**DELEGATED DECISION FOR APPLICATION FOR CERTIFICATE OF  
LAWFUL DEVELOPMENT**

Reference no.: 2025/CL/93508/E

Site: 14, Manor Road, Farnley Tyas, Huddersfield, HD4  
6UL

Description: Certificate of lawfulness for proposed erection of  
single storey rear extension (within a Conservation Area)

General Arrangement as Proposed

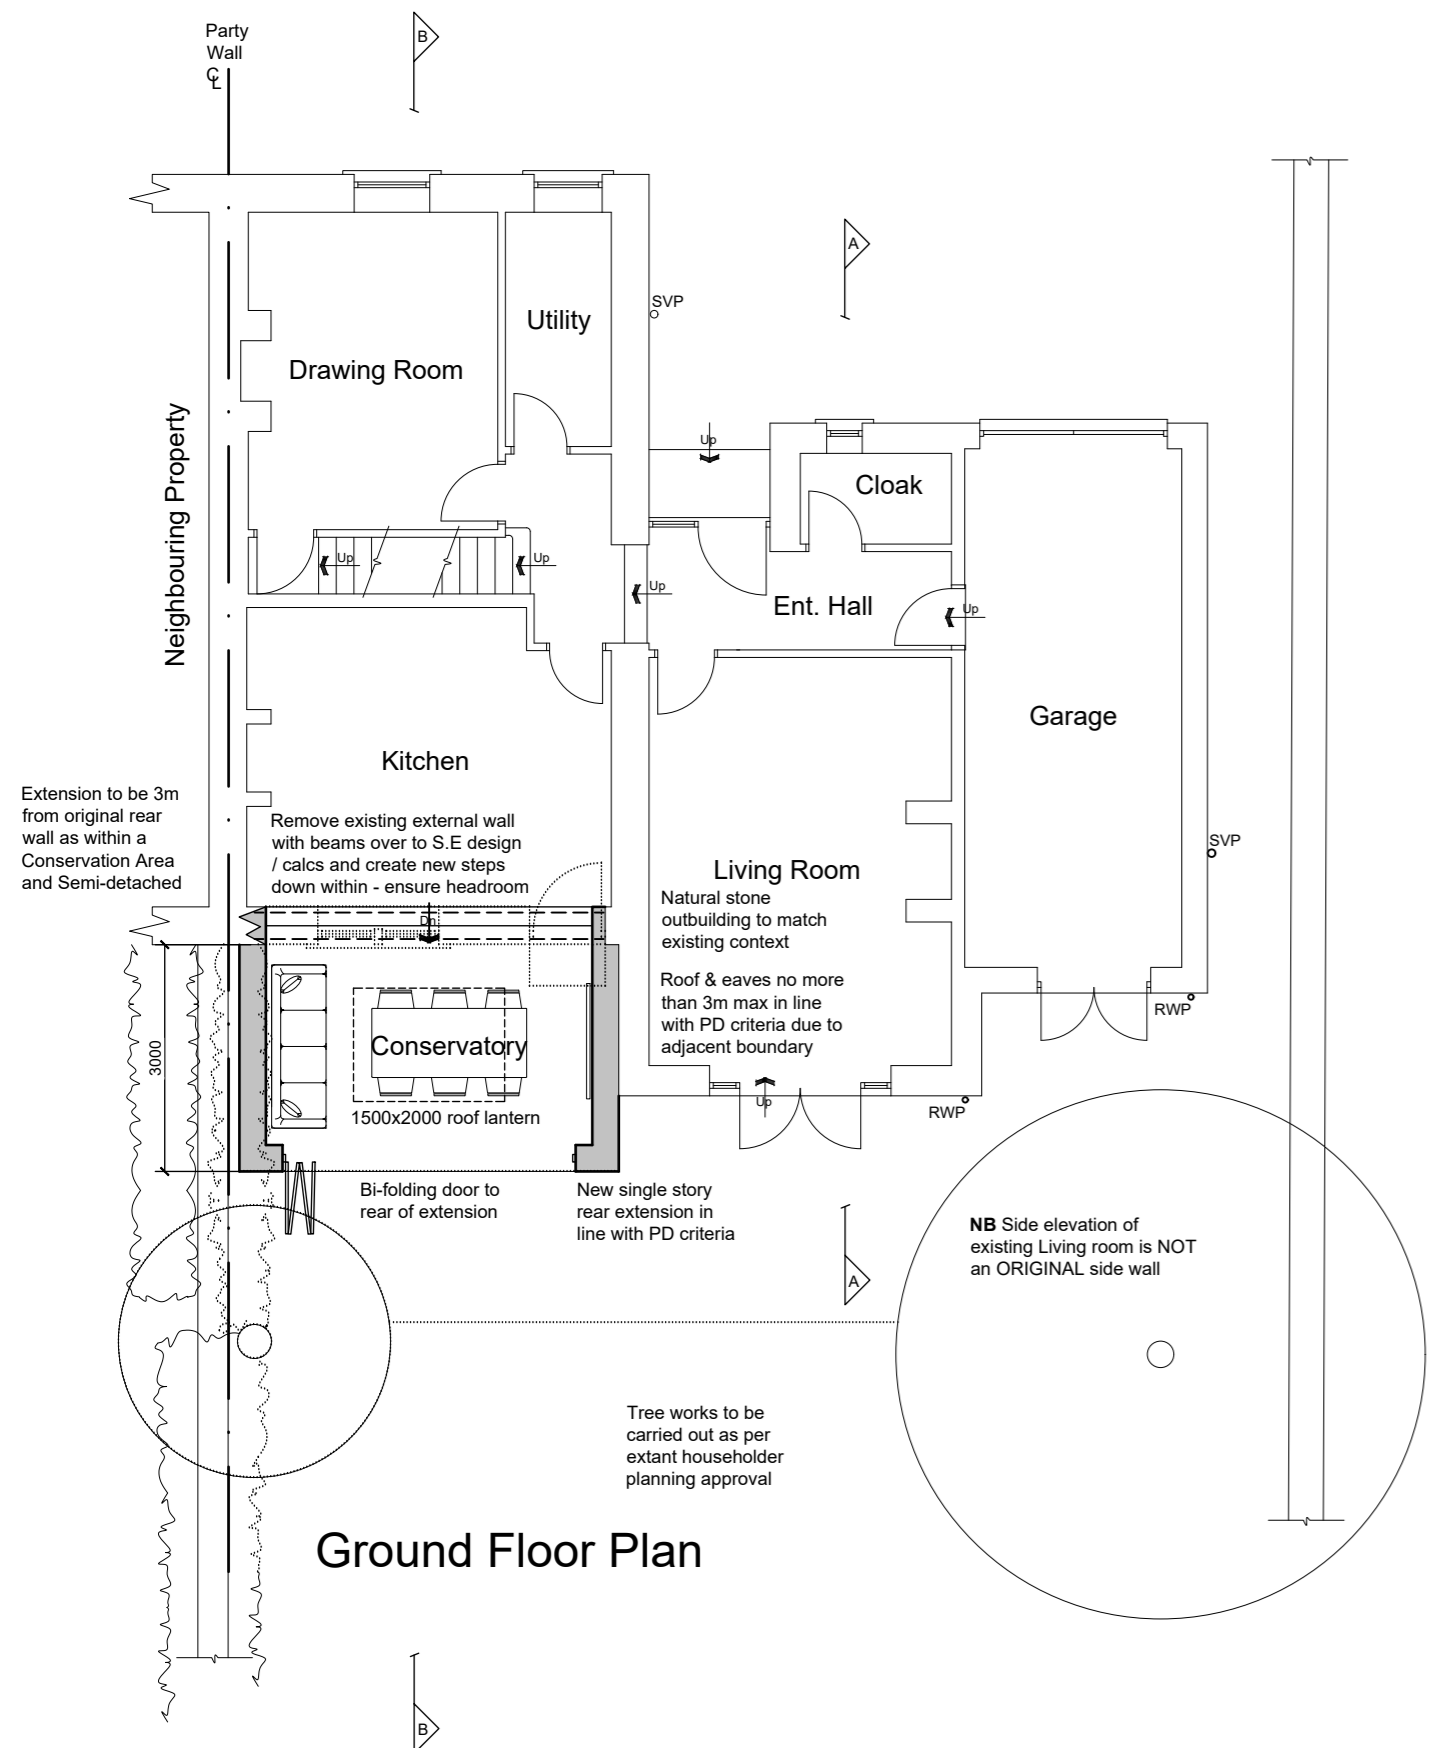
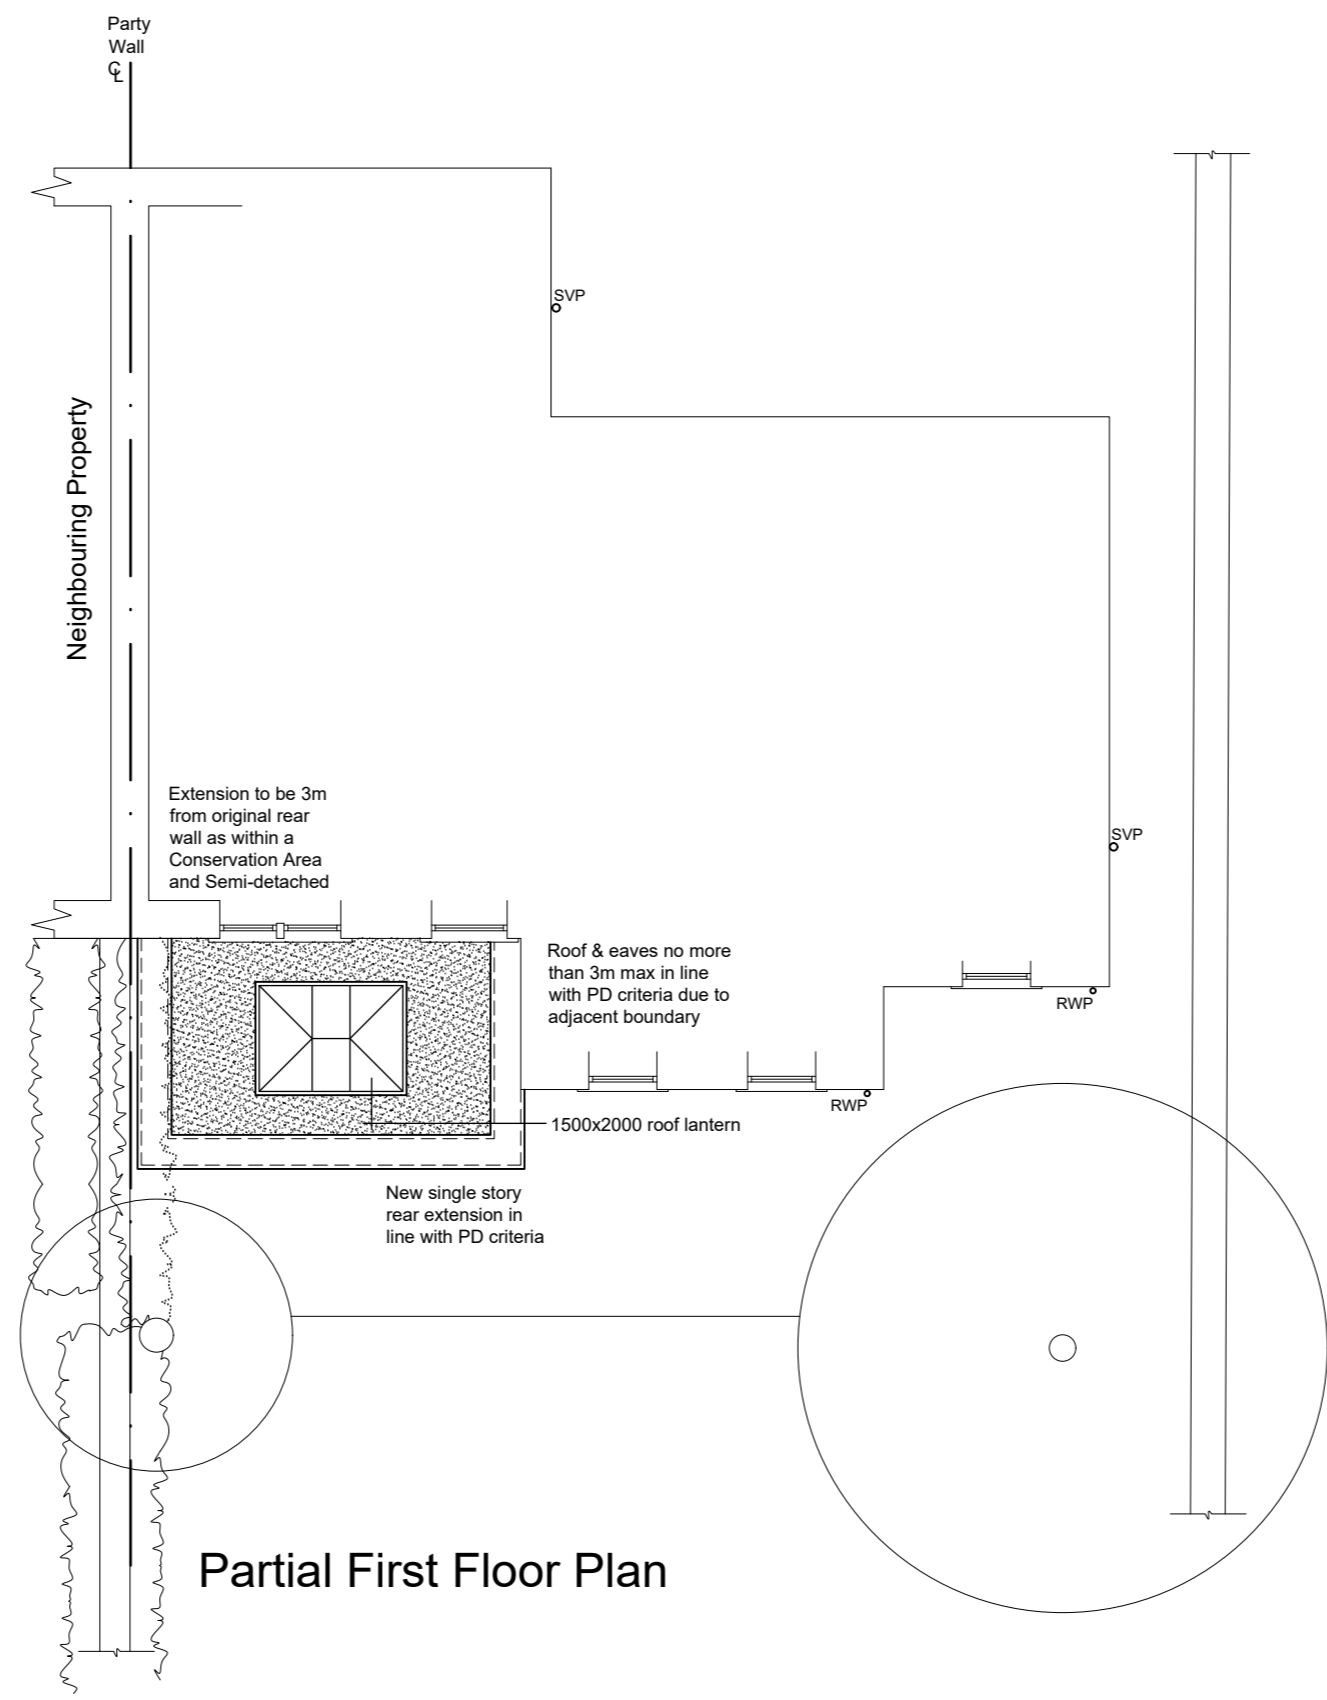
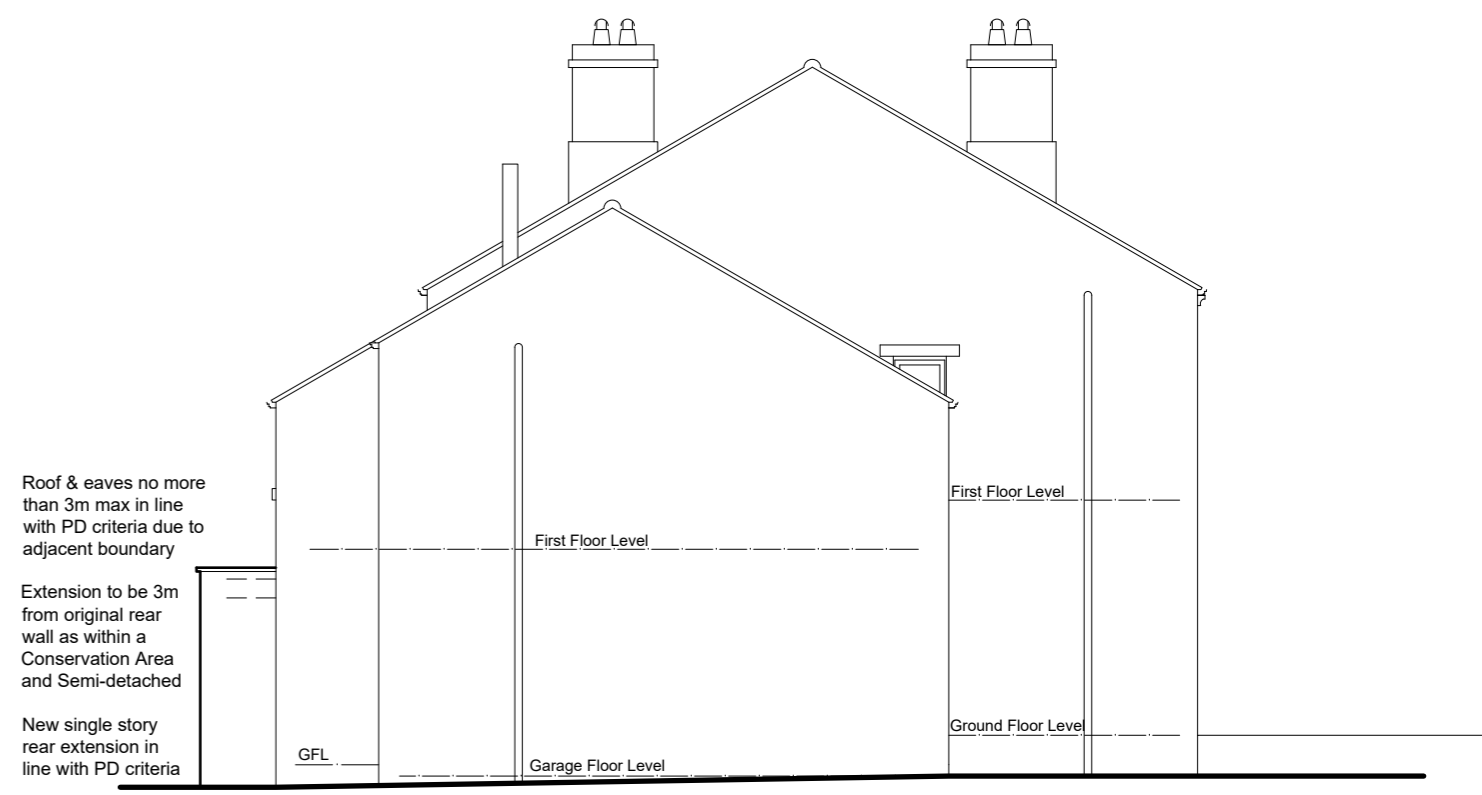
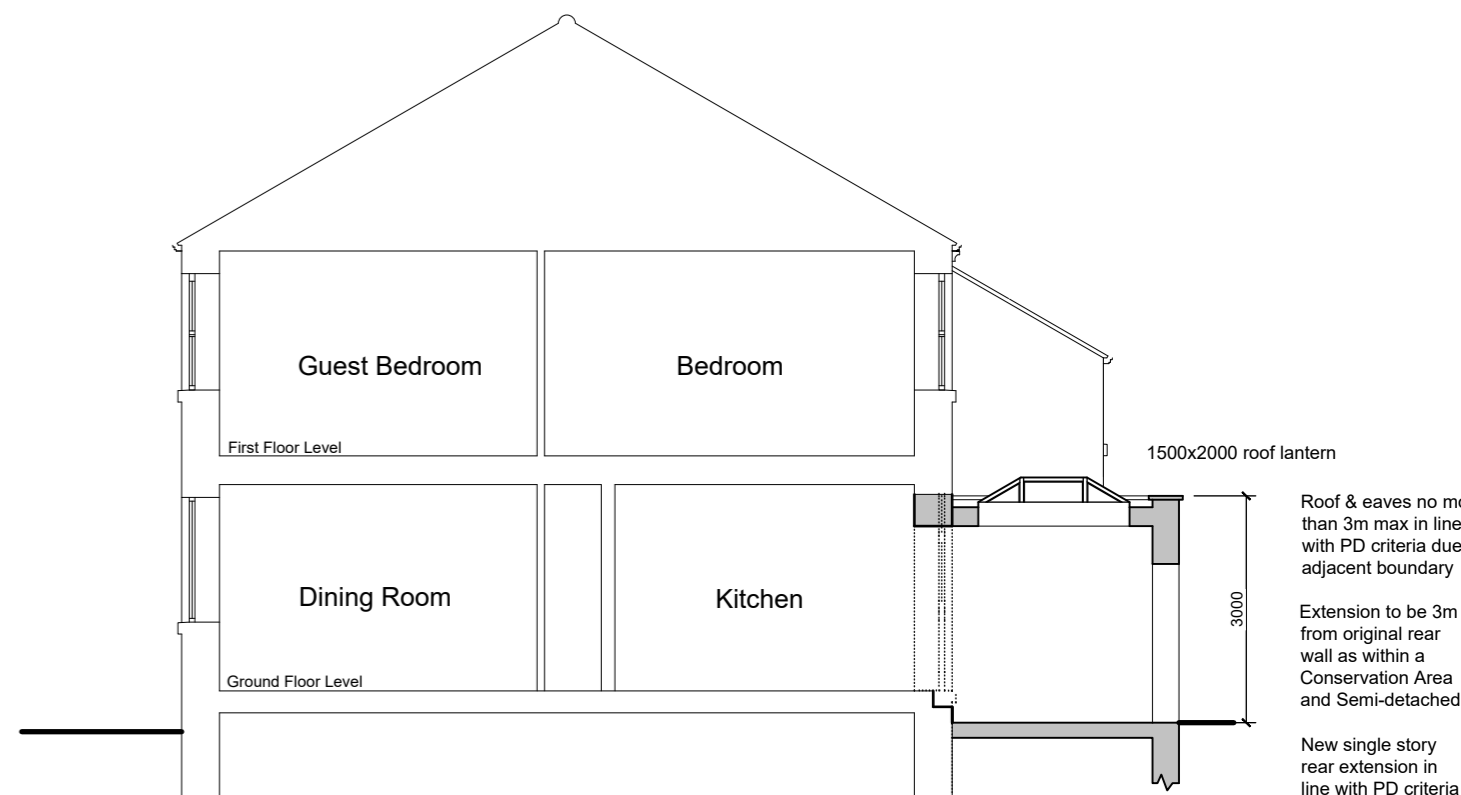
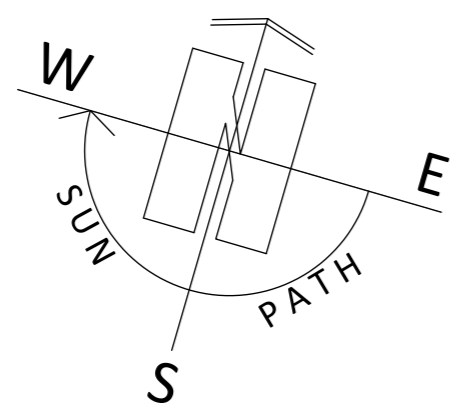
The extension would be located to the rear of the property attaching to the existing two storey side extension. The extension would span the full width of the 'original' rear elevation projecting 3 metres with a height of 3 metres with a roof lantern on the top of the flat roof.

**Comment:** *The enlarged part of the dwellinghouse would extend beyond a wall forming a side elevation of the original dwellinghouse, have more than one storey, will exceed 4 metres in height and be more than half the width of the original dwellinghouse by reason of attachment to the existing two storey enlargement to the original dwellinghouse..*

**Comment:** *The plans demonstrate that the proposed enlargement would attach to the side wall of a previous enlargement to the property. Under application 2016/93524 the dwellinghouse implemented permission to extend the property by virtue of a two storey side elevation. As advised on page 28 (ja) of the Permitted development rights for householders - Technical Advice document, 'Where the proposed extension is to be joined to an existing extension to the original house, whether that was built following a planning application or under permitted development rights, the total enlargement (being the proposed extension together with the previous extension) must*

meet the limits set out in (e) to (j) above (see examples on pages 18, 21 and 27).’

Therefore, in this case, the proposed enlargement would attach to a previous enlargement to the property and would therefore fail to comply with (e), (i) and (j) above.

The proposed single storey rear extension does not benefit from a general planning permission granted by virtue of Article 3(1) and Schedule 2, Part 1, Class A of the Town and Country Planning (General Permitted Development) (England) Order 2015 (as amended) as it would adjoin an existing enlargement to the original dwellinghouse and as a total enlargement would be contrary to sub-paragraphs A.1 (f), (i) and (j) by reason of sub-paragraph A.1 (ja) of Class A.

Proposed Block Plan

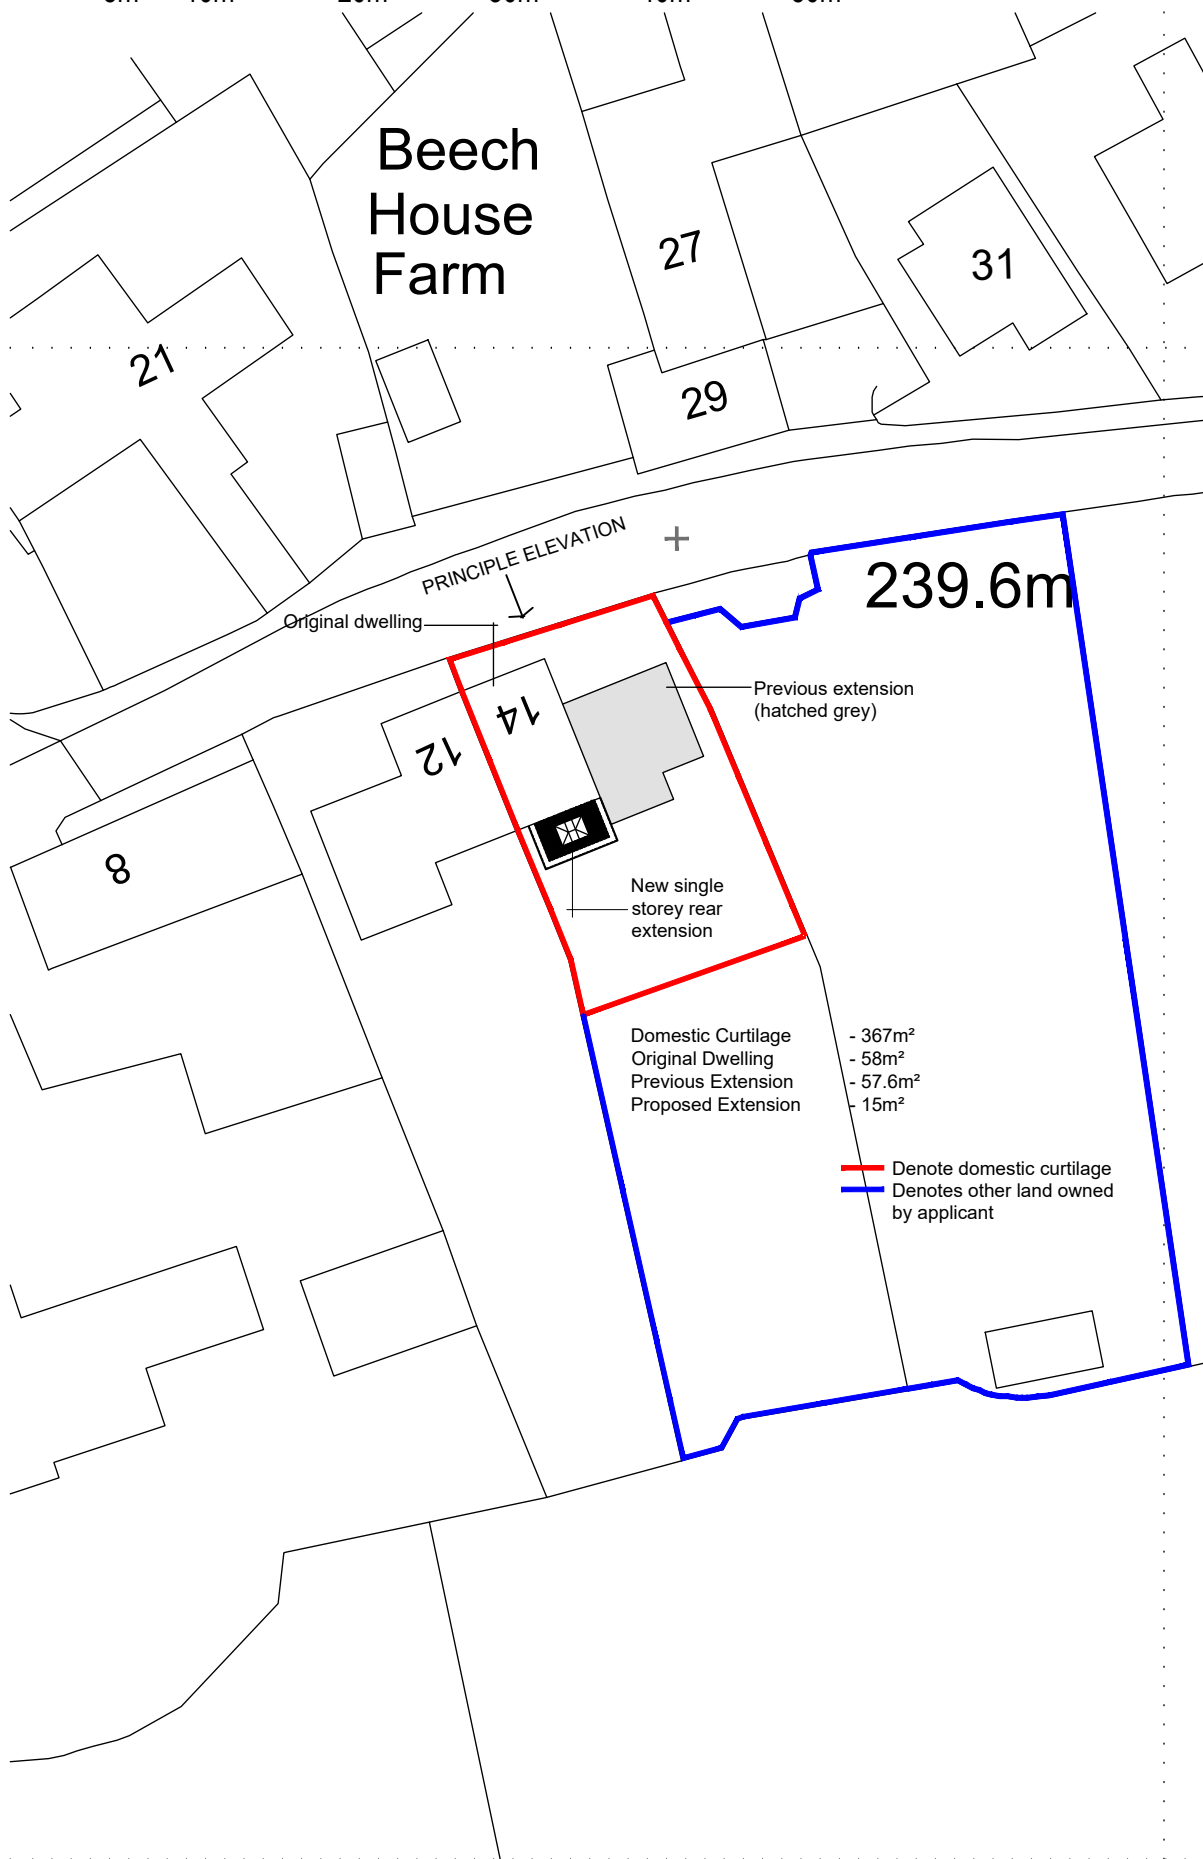
***Comment:*** *The total area of ground covered by buildings (including the garage/outbuilding which is not an original feature) would not exceed 50% of the total area of the curtilage of the dwellinghouse.*
